Item No. **Report of the Head of Planning, Building Control, Sport & Green Spaces**

Address COLHAM MANOR PRIMARY SCHOOL VIOLET AVENUE HILLINGDON

Development: Extension to playground and installation of timber fence

LBH Ref Nos: **8721/APP/2014/343**

Drawing Title
Proposed Plan

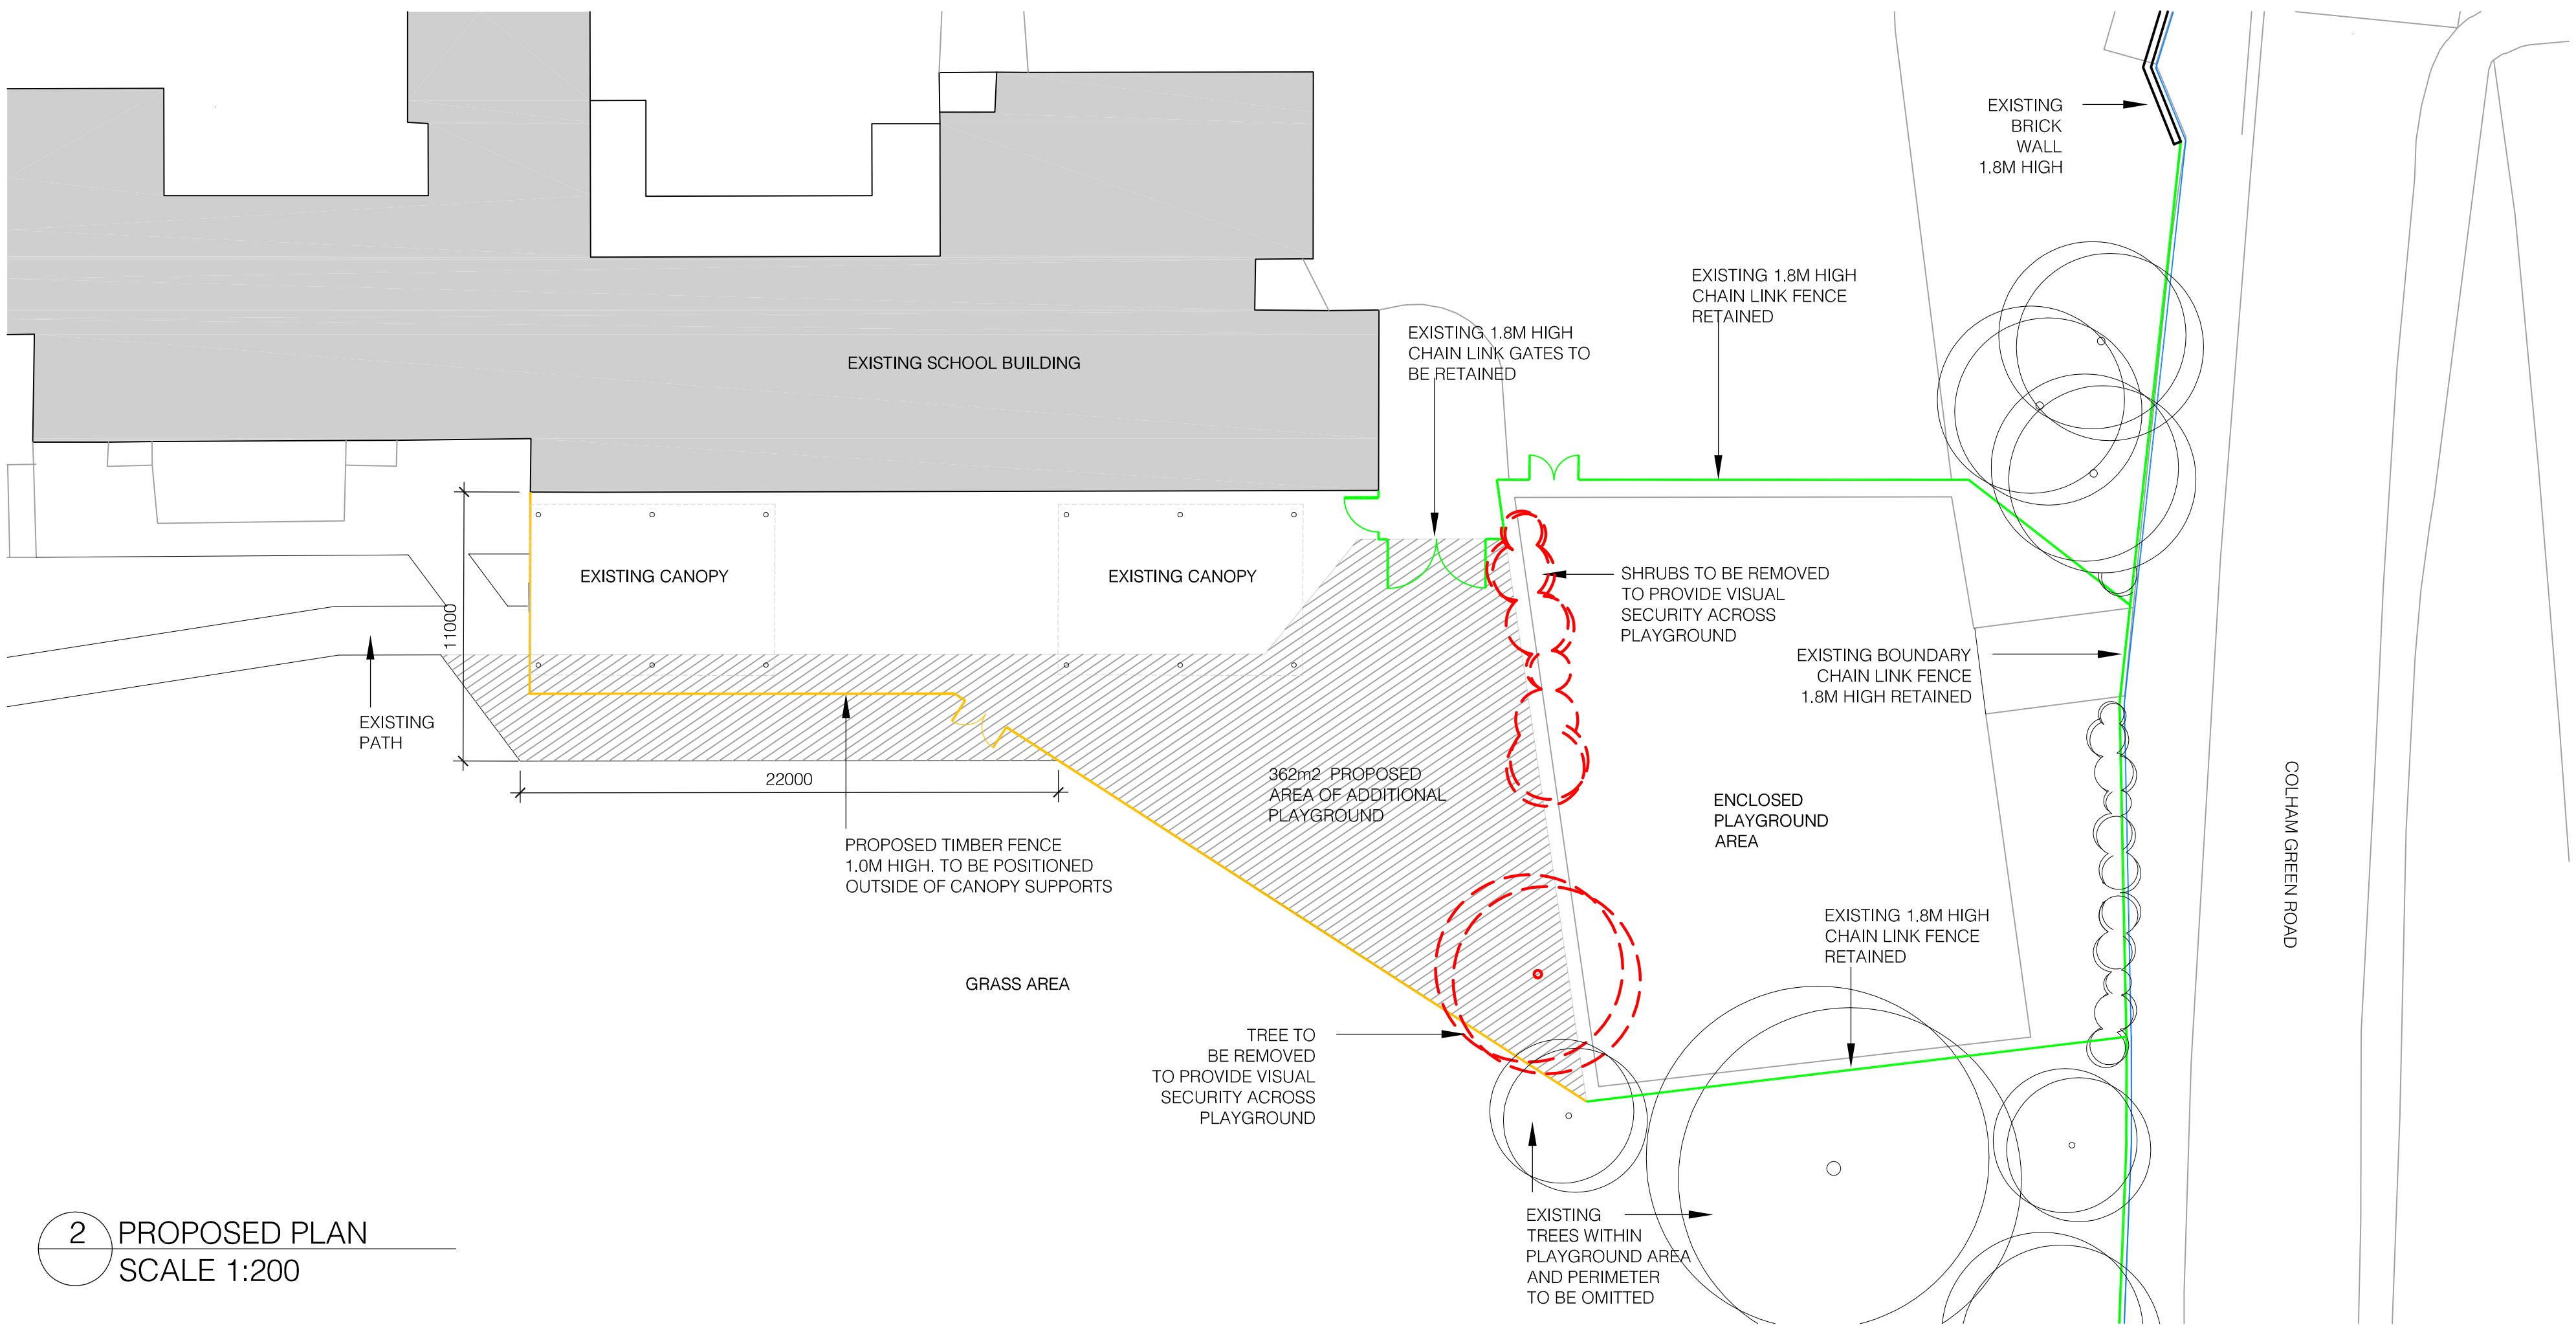
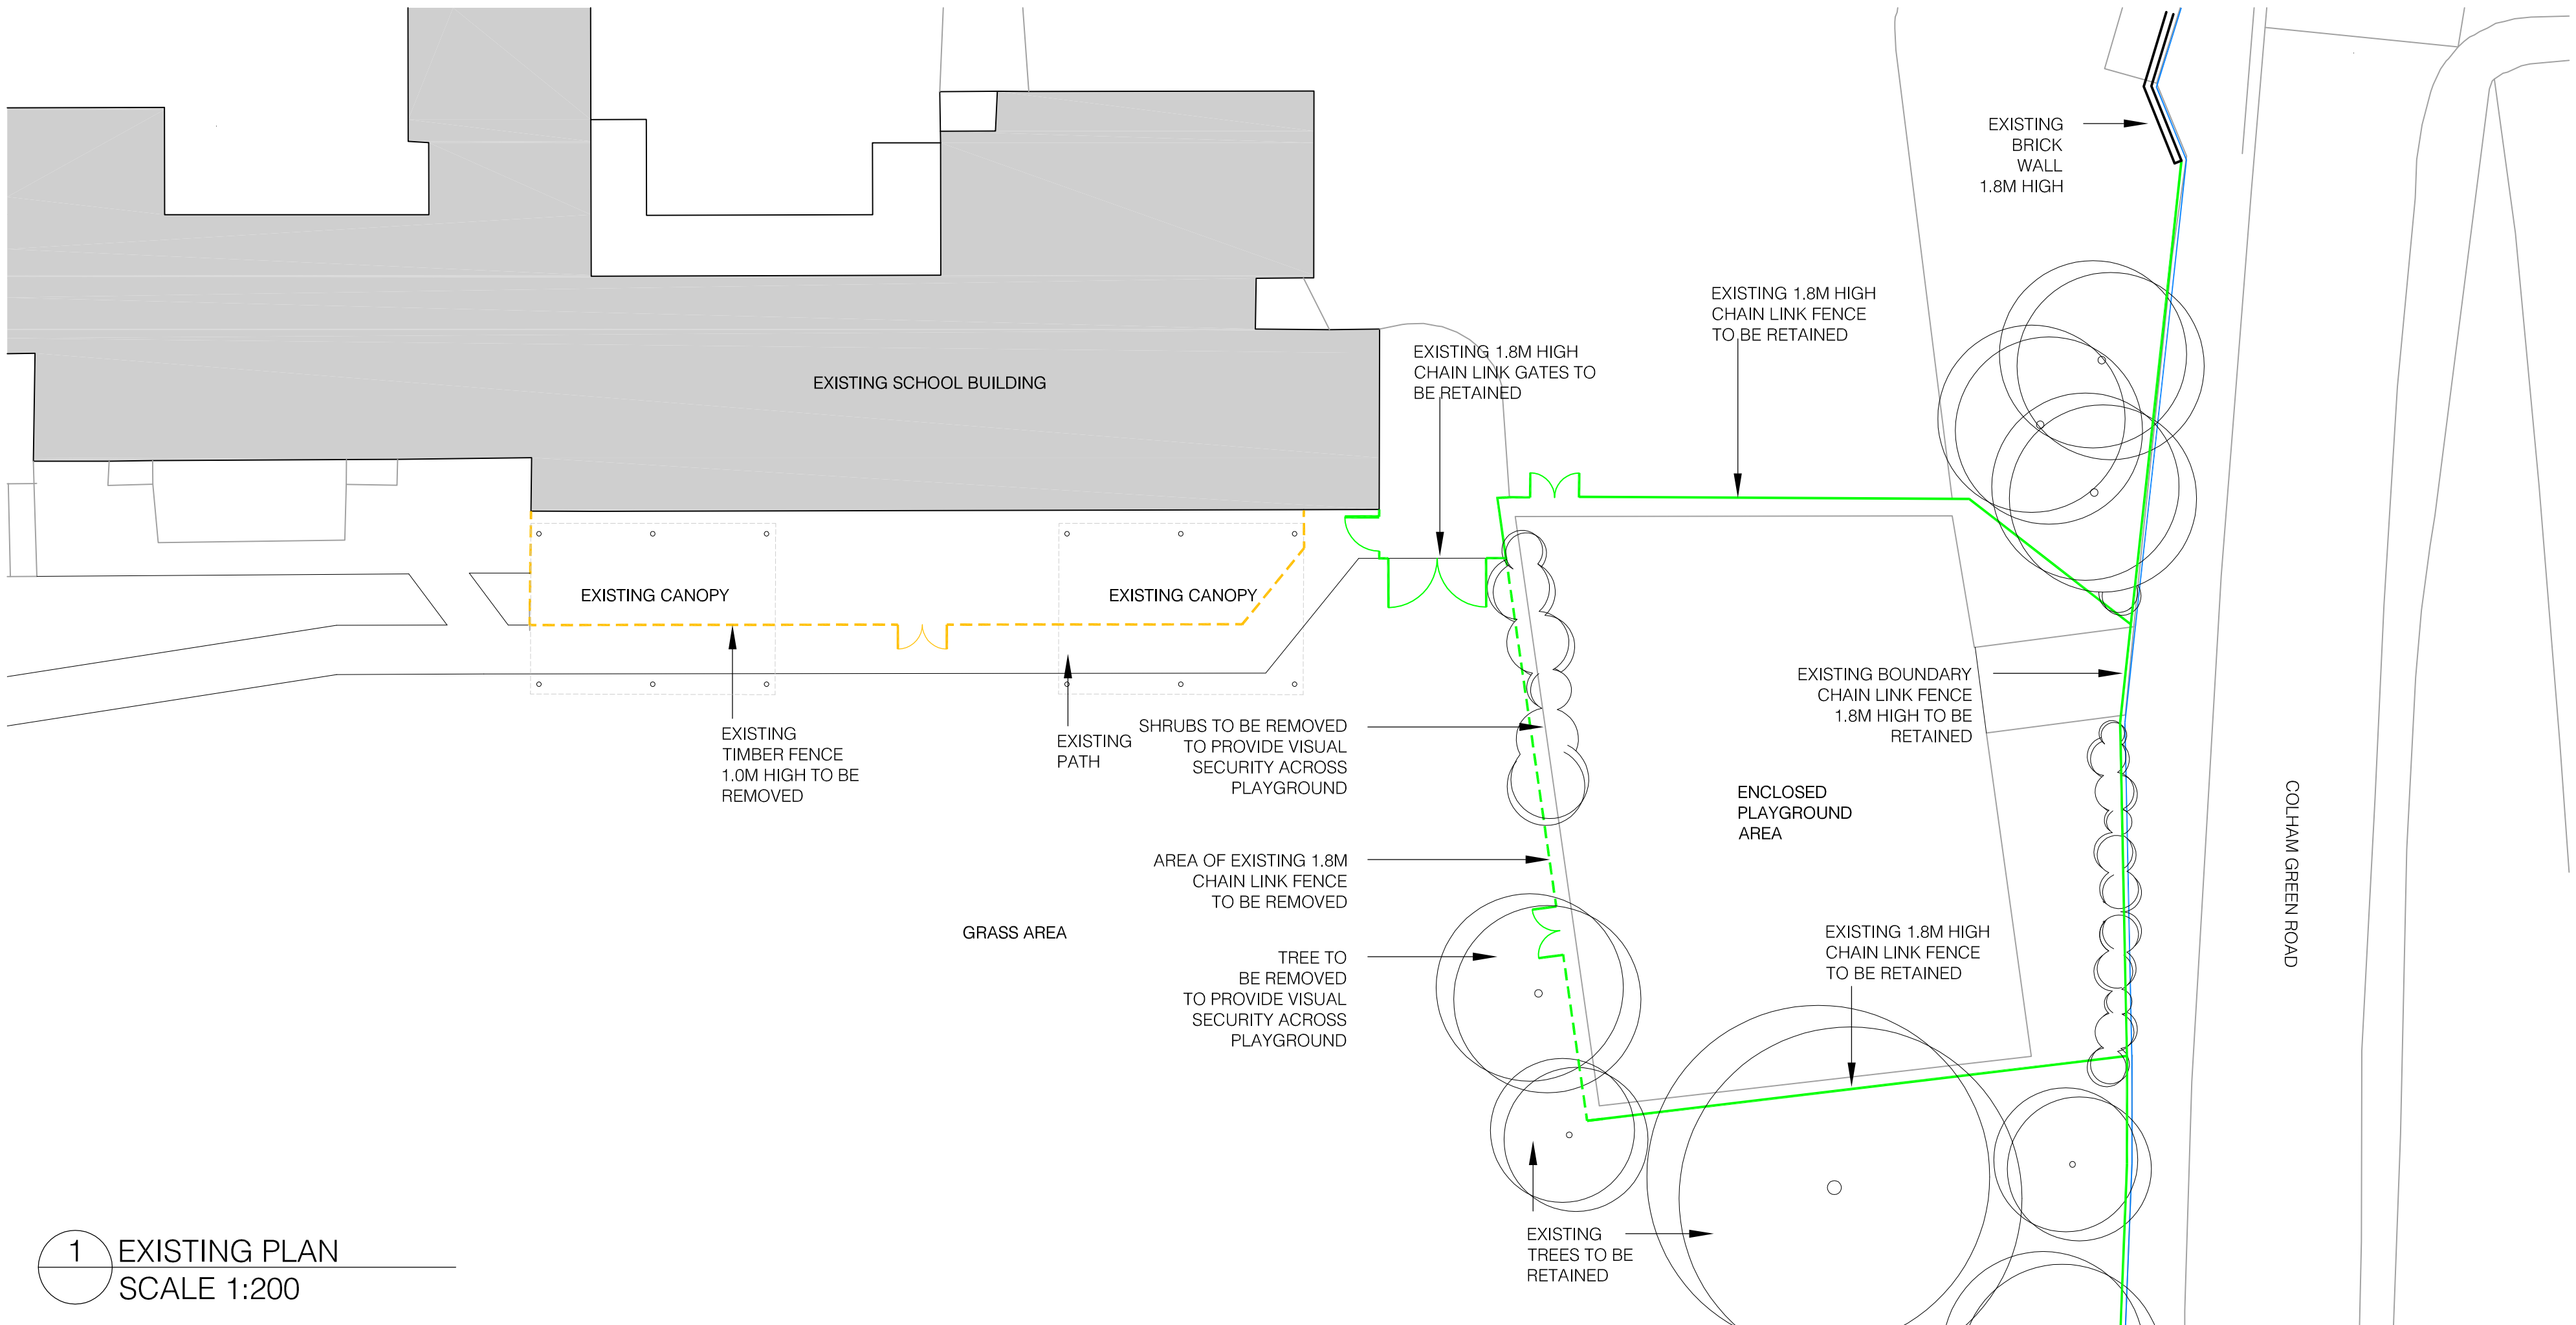
You are advised that consideration should be given to the drainage methods for surface water on the extended playground. The level of hardstanding would result in increased surface water collection during periods of heavy rainfall, which may result in flooding of the hard play area or adjacent playing fields without a sufficient drainage system.

- The Proposed Plan, drawing No. P-002 indicates the location of the existing play area with its associated planting and pedestrian access onto Colham Green Road, with the school building set back slightly to the west.

- The Existing Plan (drawing No. P-002) shows the extent of the additional hard surfacing, the retention of existing 1.8metre high chain link fencing to the south and east boundaries, and the introduction of lower (1.0metre high) timber palisade fencing around the outer edge of the new surfacing. It also indicates the removal of a number of shrubs and a small tree - 'to provide un-obscured visual security across the playground'.

- While the removal of shrubs is understandable (they may provide a dense, child high screen at eye-level), it is not clear why the clear-stemmed is to be removed. It would not be possible to hide behind it. Furthermore, this playground is relatively unsheltered and exposed to sunlight. Occasional, light shading is normally considered desirable in a play area?

- While there is no objection to the proposal in principle, it would be preferable to retain the tree, failing which, replacement tree planting should be provided in a suitable location.

Whilst not located within the Green Belt, the application site lies adjacent to the Green Belt. The playground would be visible from Colman Green Road and would include the loss of a tree and approximately 11m row of shrubs. Whilst the loss of this vegetation is regrettable, the applicant has advised that it is required to increase surveillance of the playground for child protection purposes. It is considered on balance that the loss of this tree and shrubs would not result in unacceptable harm to the character and appearance of the site and surroundings. The loss could further be mitigated against by the planting of a replacement tree and shrubs within the application site which could be secured by condition. The proposed fence would have an acceptable impact on the appearance of the site. As a result it is considered that it would not have a negative impact upon the visual amenity of the site or the surrounding area in compliance with Local Plan policies BE13 and BE15.

No development shall take place until a landscape scheme has been submitted to and approved in writing by the Local Planning Authority. The scheme shall include: -
